Sizewell C (SZC)

Planning Inspectorate Reference: *EN010012*

Deadline 3 – 24 June 2021

Comments on any additional submissions received at D2

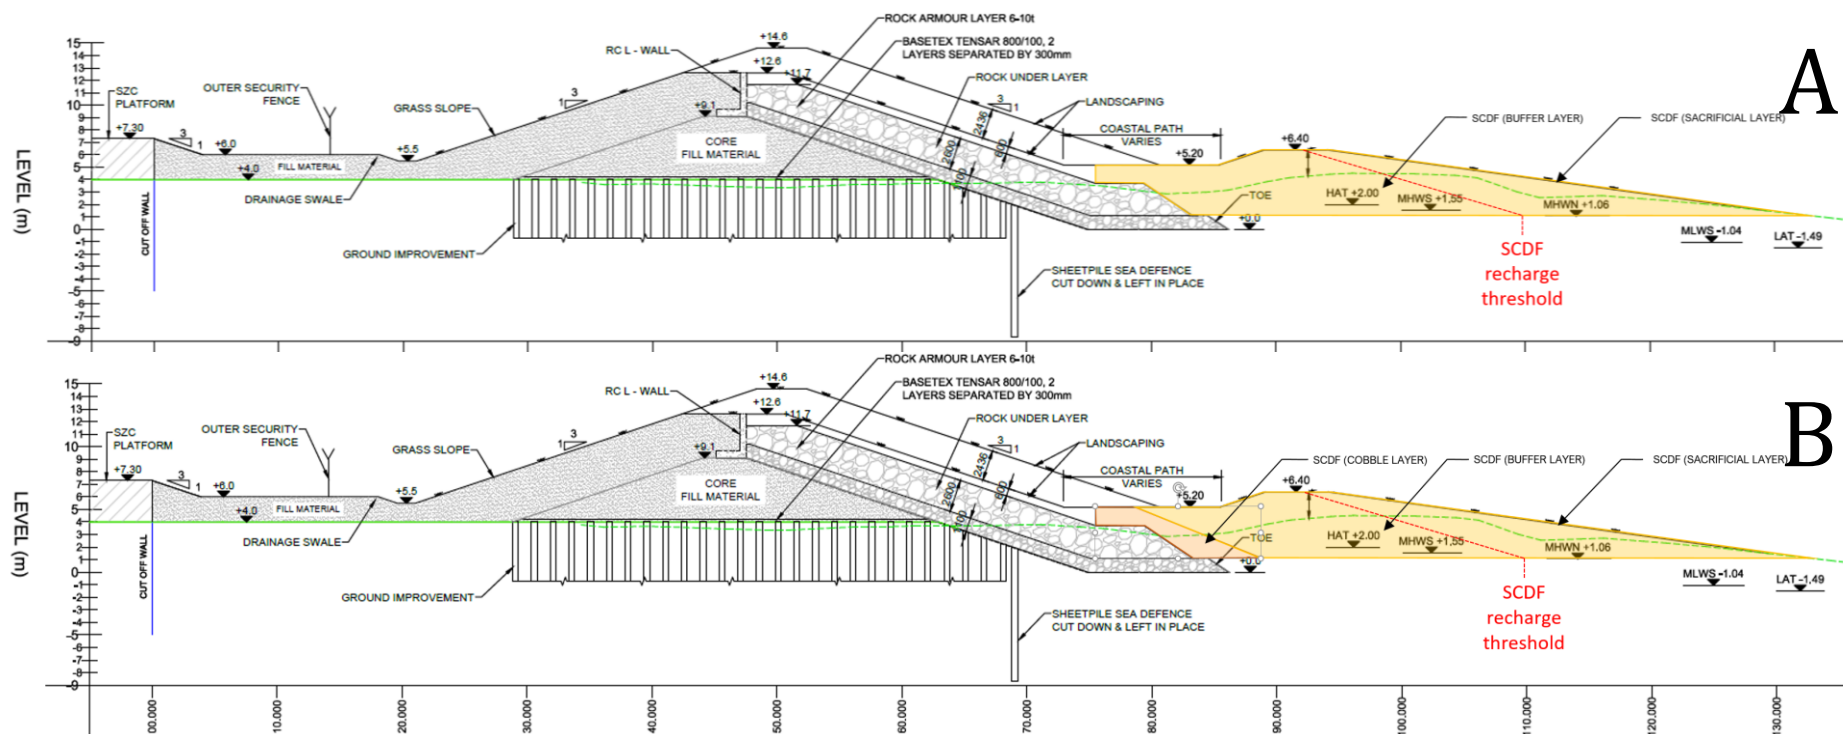
19	Fig 4 B		It appears that Cobbles will be exposed at Coastal Path surface level.	In alignment with SCC PRoW team we continue to seek the PROW to be on the top of the sea defence.
20		An initial suggested working value for V_{buffer} is 2 – 3 times the conservative storm erosion value of 40 m ³ /m. At 80 – 120 m ³ /m, V_{vac} would be in the range 42 – 477 m ³ /m. Note that there may be rationale to raise the value of V_{buffer} in the	Avoiding shoreline curvature around the north face - a new issue.	Explain the concern and potential for shoreline curvature – is this suggestive of the higher erosion rate to the north of the main

Figure 6: Topographic maps of the current and proposed SCDF topography.

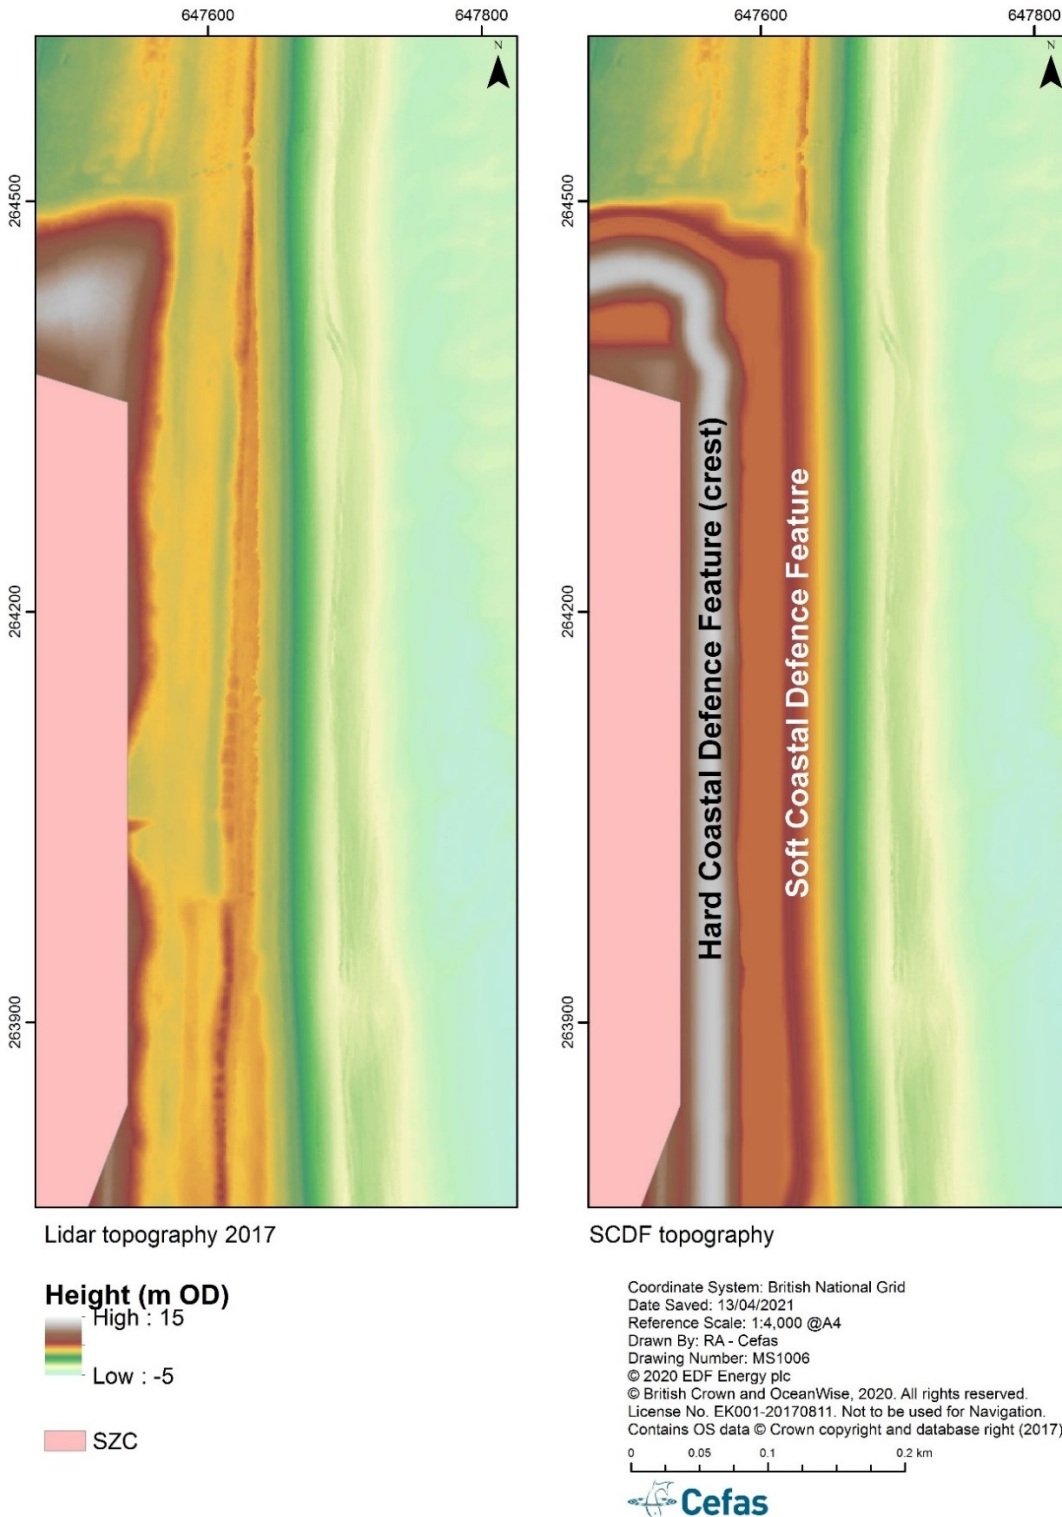
<i>northern SCDF sections to avoid shoreline curvature around the north face, however that matter is considered a refinement and is not resolved in this initial study.</i>		development site/ around northern mound?
Pg. No.	Section Ref.	Relevant Text / illustration	Observations and Concerns	Requested:
21 22	Fig 6 Fig 7		The HCDF plan position, and SCDF volume calcs, do not show the latest HCDF design seen in the Engineering report (3/6) that has a seaward kick out at the South end.	Update plans and SCDF volume calculations based upon latest Engineering Report content.
21	Fig 6		<p>The colour contours clearly show how the SCDF would wrap around the north end of the HCDF, turning westwards / landwards at the end of the developed site.</p> <p>Clearly from the safety perspective the coastal defence cannot be allowed to be breach should shoreline retreat progress up to and beyond the HCDF (outflanking). Were this situation to arise then continuity of natural longshore transport towards Thorpeness would be interrupted (notwithstanding secondary mitigation).</p>	Please clarify/comment on the how this situation might develop and be countered if/when the situation occurs.
